Review comments provided by:
Jack Patton
jackpatton@elpasoco.com
(719) 505-0236

- Notes for the future site plan:

# REZONE MAP

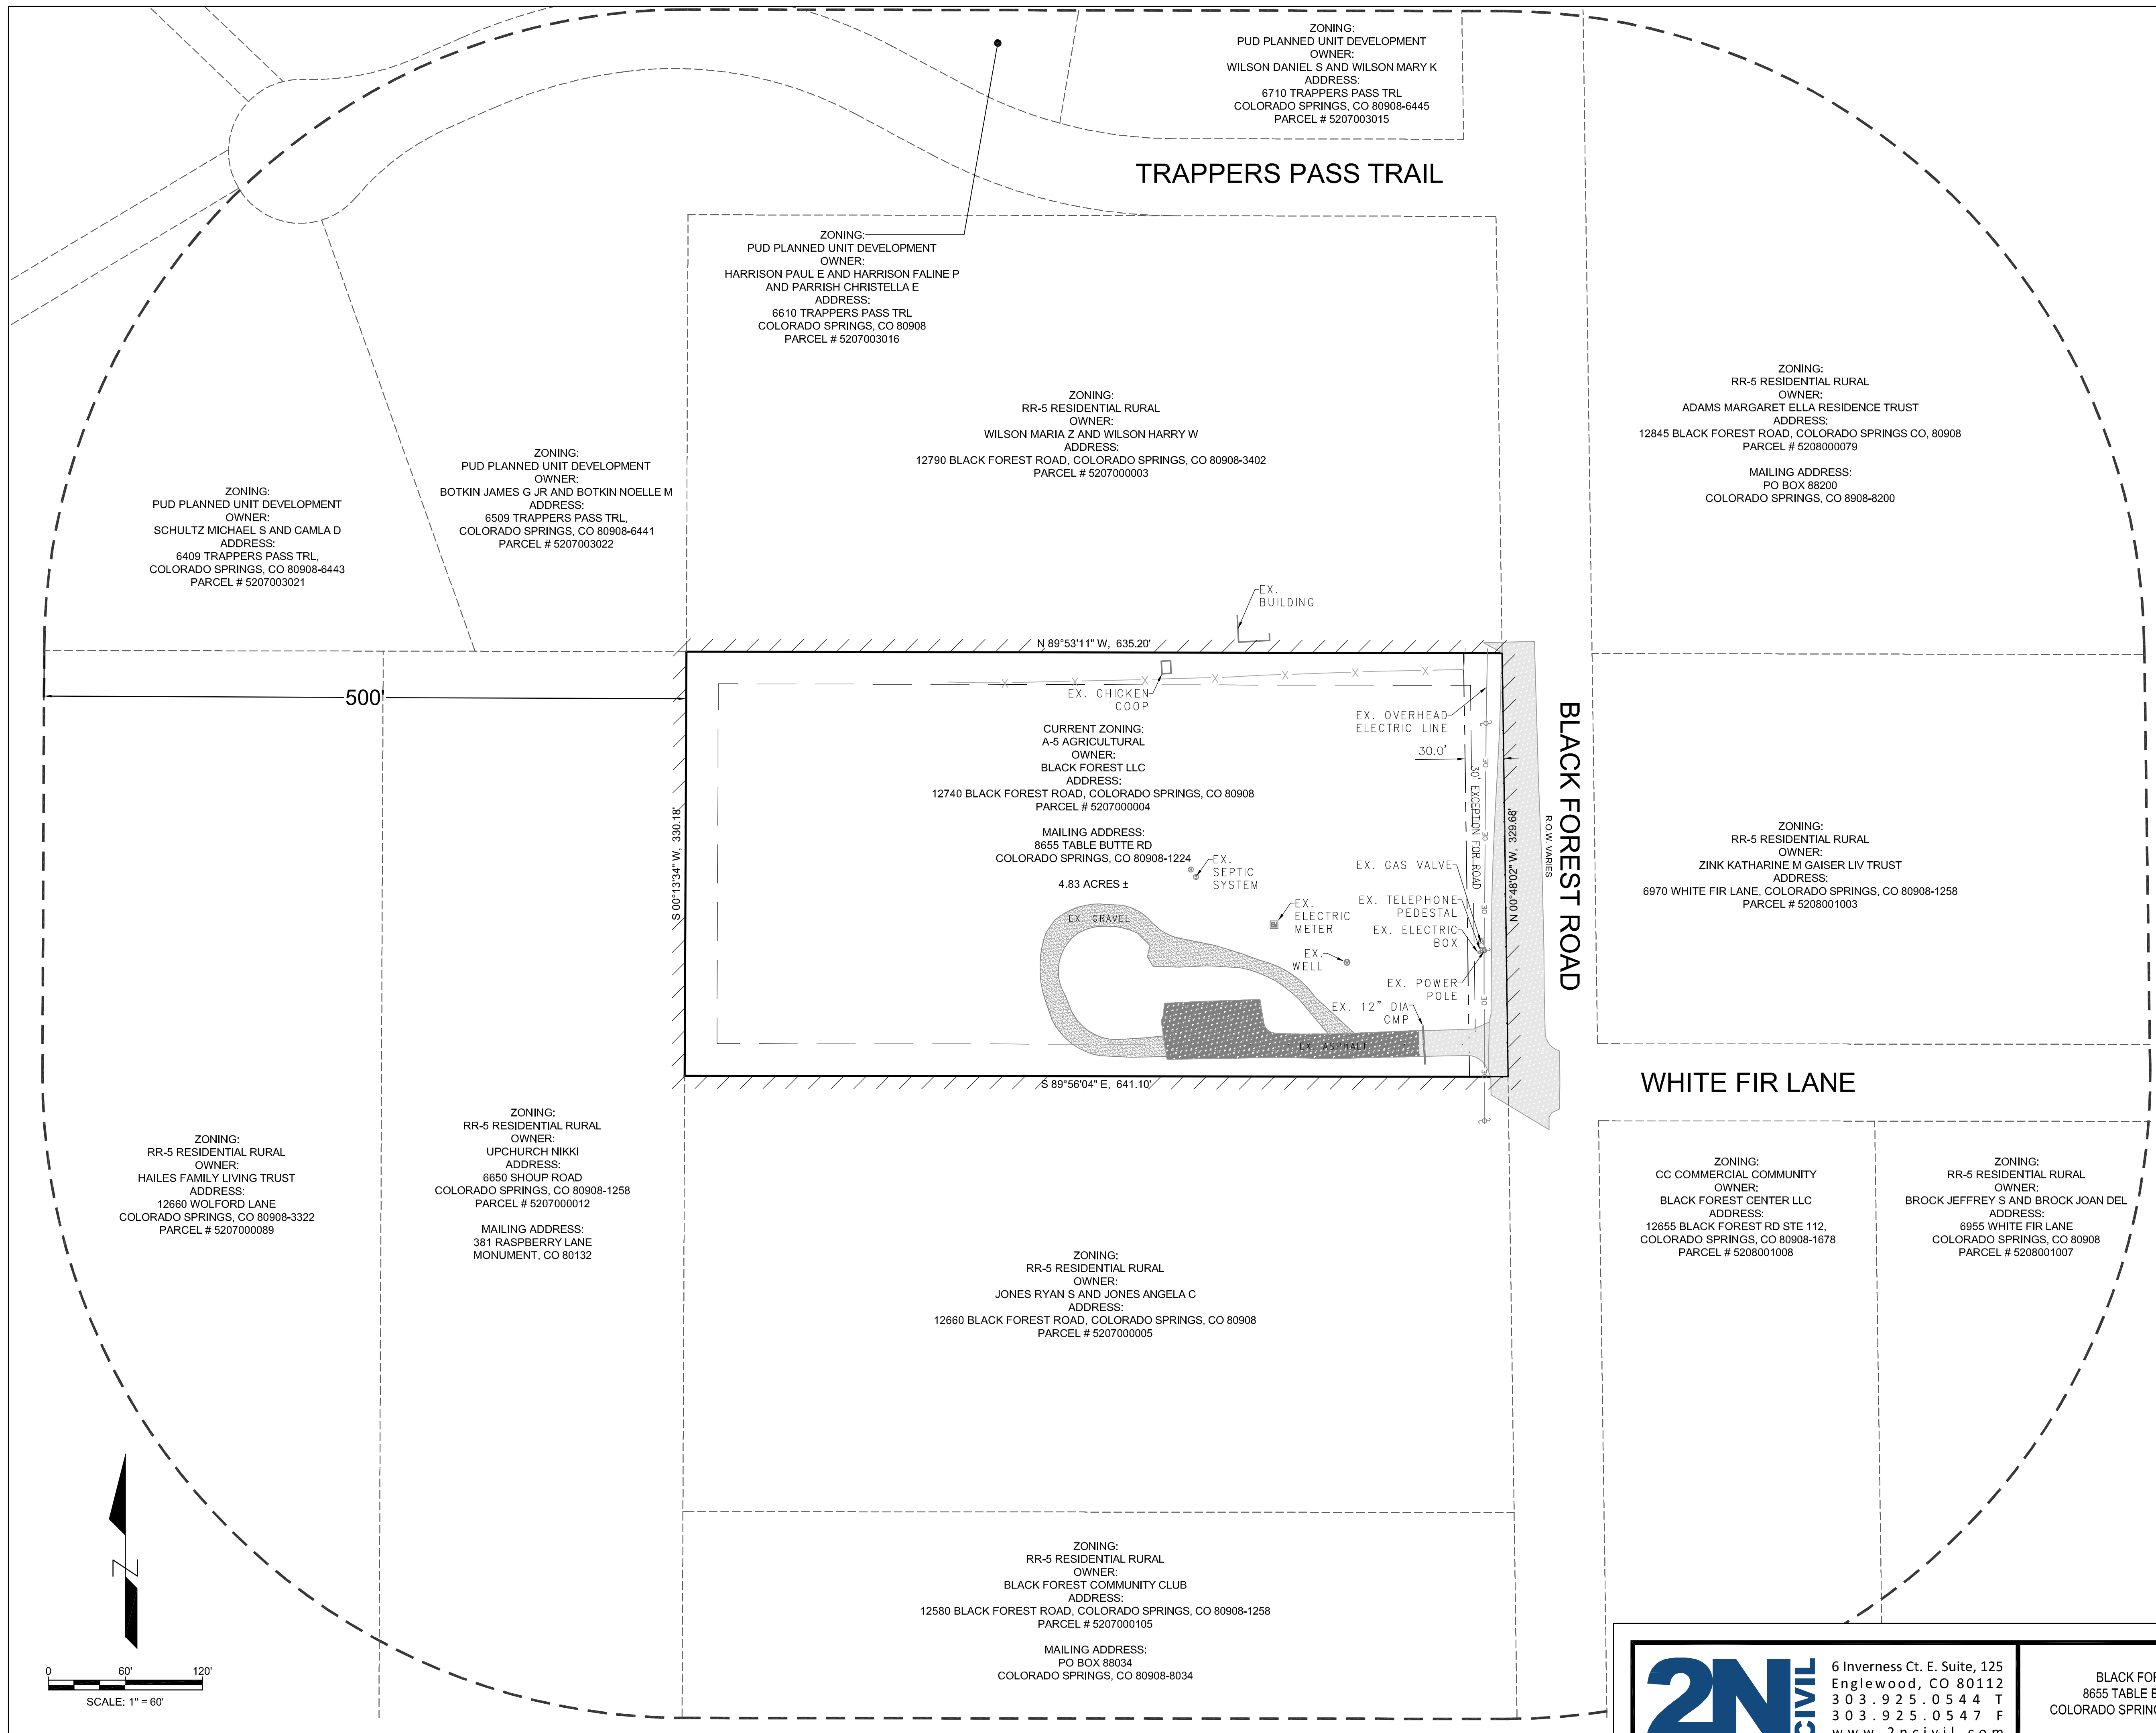
(1) Per the 2016 Major Transportation Corridor Plan, that section of Black Forest Road is included on the 2060 Corridor Preservation Plan to be a 4-lane Minor Arterial road that would require 180' of right of way (ROW) dedication. There appears to currently be approximately 70' of ROW. The remainder will be required to be shown on the future site development plan and all setbacks will begin at that point.

(2) The driveway location shown on the preliminary site plan does not meet the access spacing required by ECM 2.4.1.F.2. Commercial access spacing is defined in this section of the Engineering Criteria Manual.
